From: Martyn White <Martyn.White@arun.gov.uk>
Sent: 22 October 2021 16:19
To: Planning.Responses <Planning.Responses@arun.gov.uk>
Subject: P/127/21/RES

P/127/21/RES

Land North of Sefter Road & 80 Rose Green Road Pagham

CB_84_139_001 Rev G Planning Layout

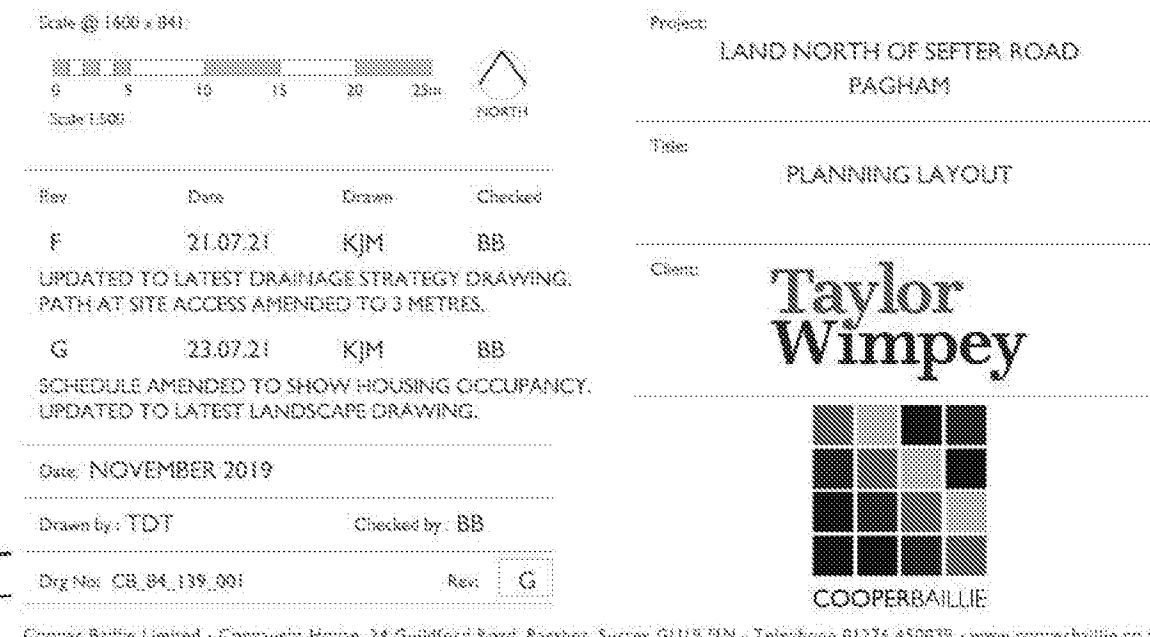
The site plan indicates that the ISP will be retained in an area of open space and that there will be a limited number of properties close to the structure. It is considered that the proposed use of this parcel of land for open space offers the opportunity to ensure that the setting of the asset can be carefully considered. I note that the soft landscaping scheme indicates that meadow planting will be located around the structure, along with some amenity grass and some rustic post and rail style fencing. Such a proposal would allow for the structure to be visible and 'better revealed' whilst also retained in a more verdant situation. Whilst such an approach is positive, the close proximity of the SUDS somewhat detracts and the area could be better utilised as further meadow land which is more sympathetic to its setting.
